CHUNG PROPERTY EXEMPTION SURVEY PLAT

A PORTION OF THE SOUTHEAST QUARTER OF SECTION 3 TOWNSHIP 12 SOUTH, RANGE 66 WEST OF THE 6TH P.M. EL PASO COUNTY, COLORADO

Add PCD File # EX-18-003

CHUNG PROPERTY EXEMPTION SURVEY PLAT

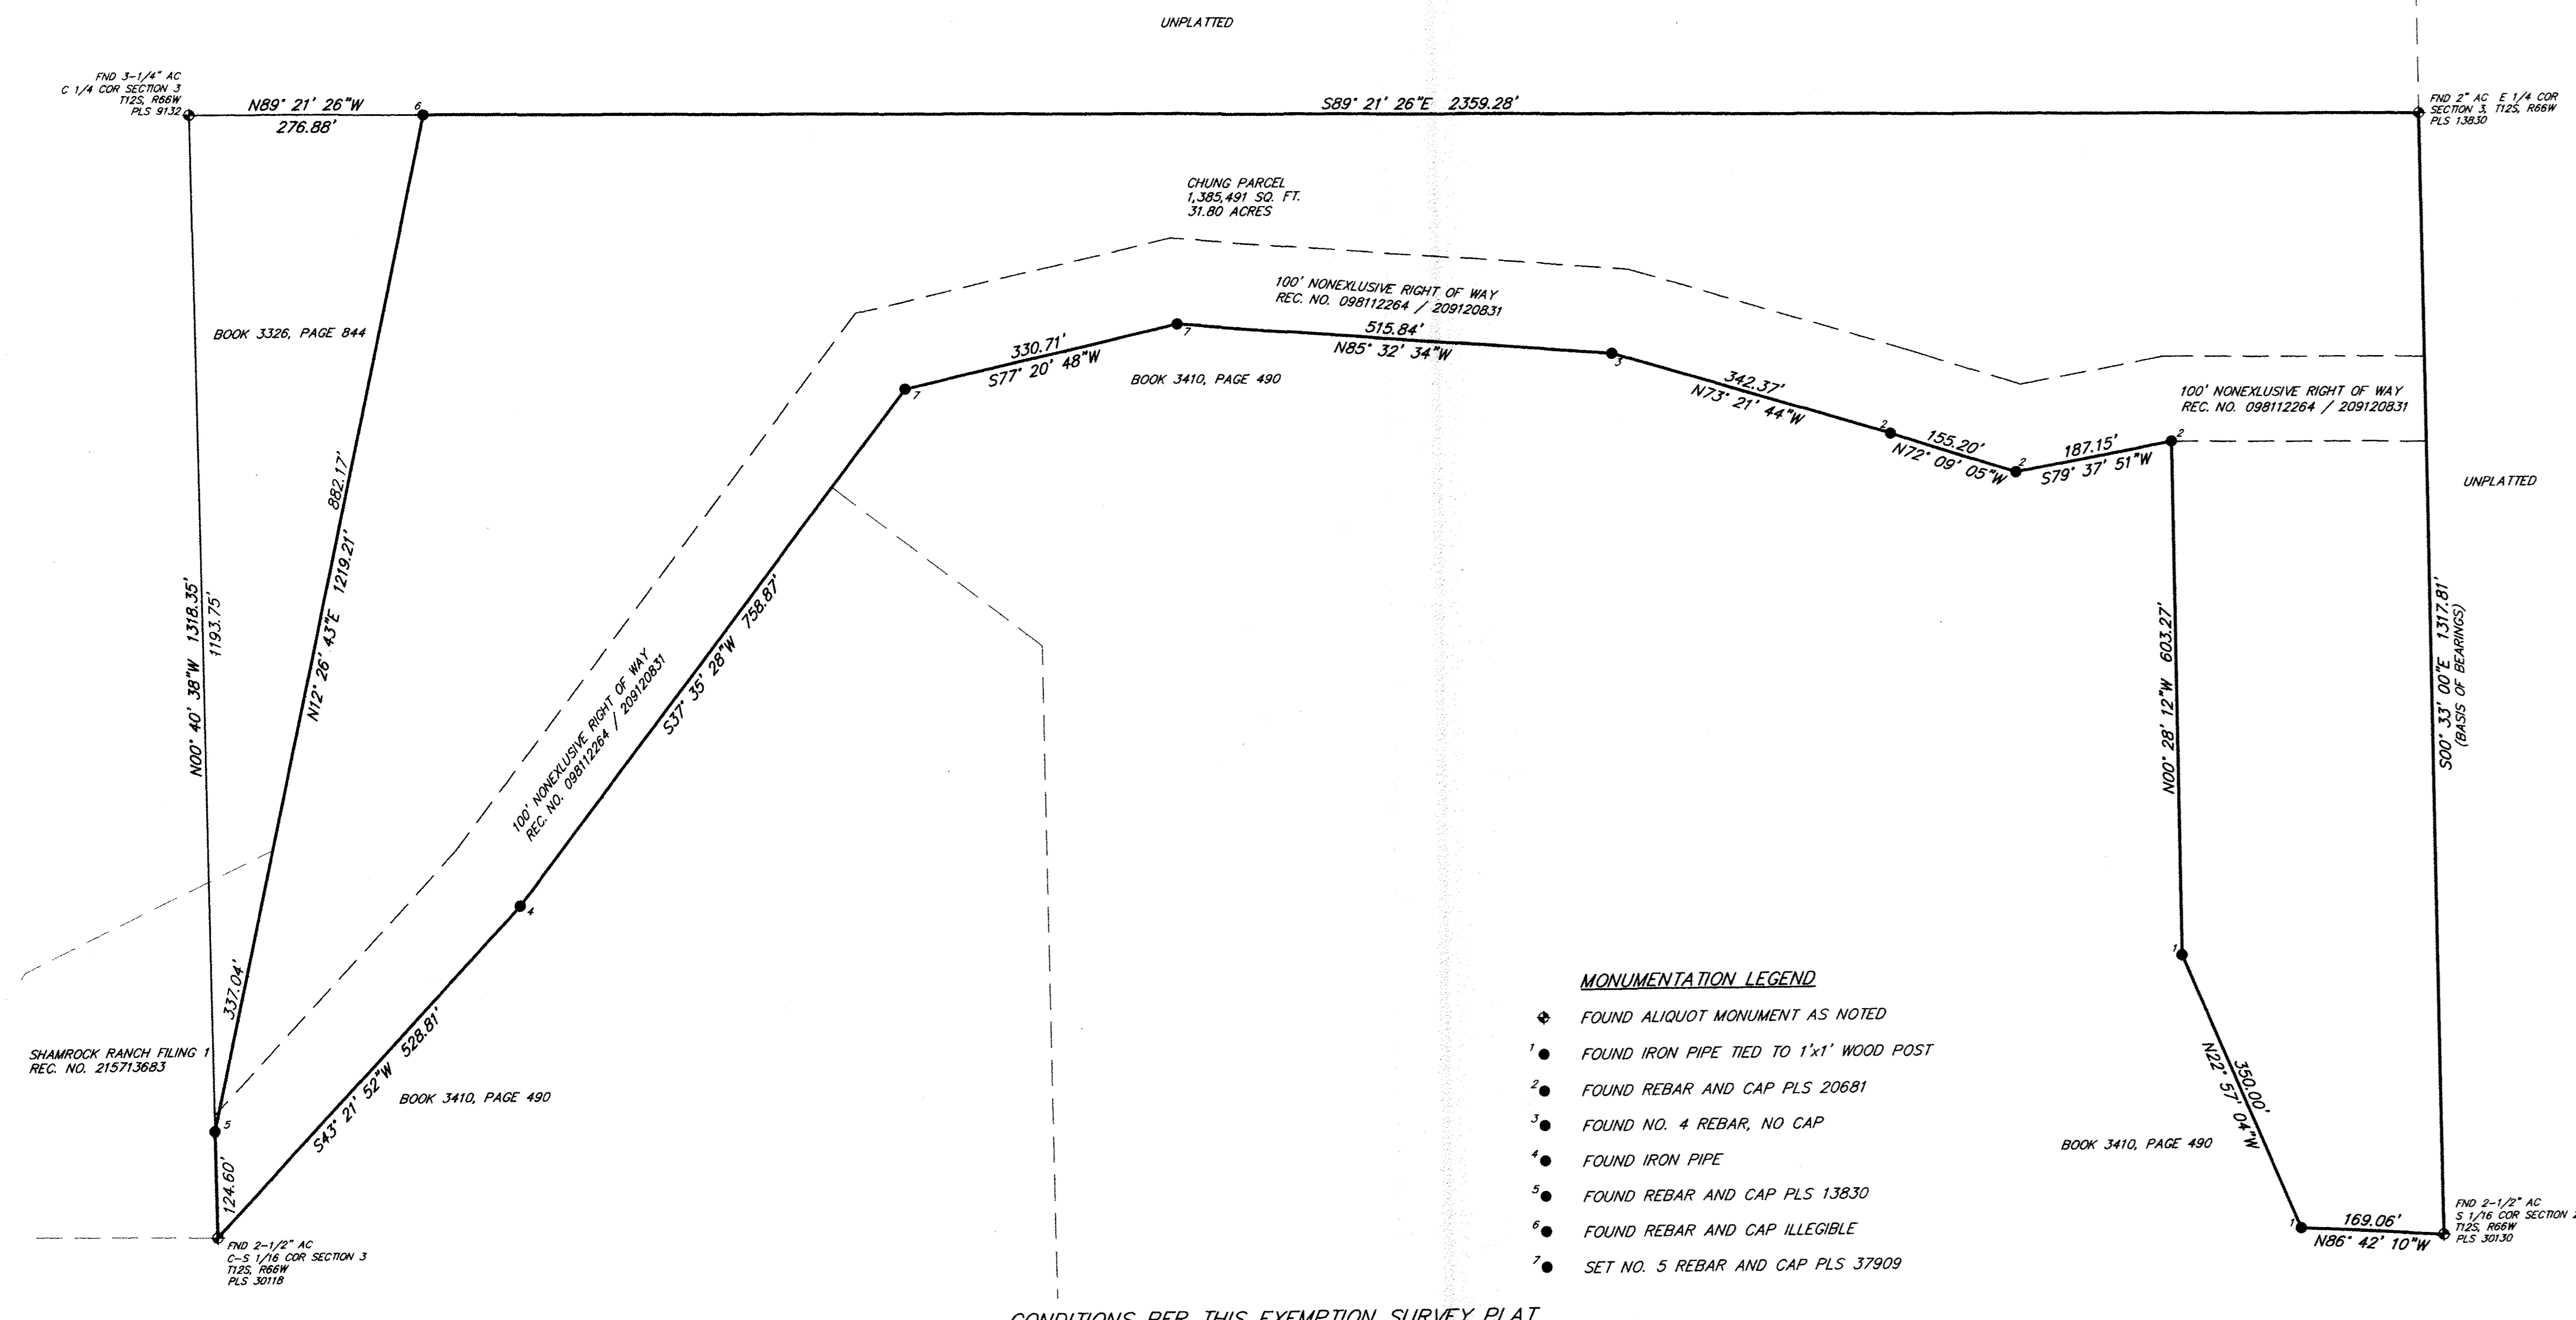
The bearings noted on this sheet differ from what is shown on the El Paso County Assessor's Office website, please confirm.

consider adding a note to reference CDOT access permit.

For the subdivision exemption you cannot create new lots. The exemption should be to simply legalize the lot as it stands today.
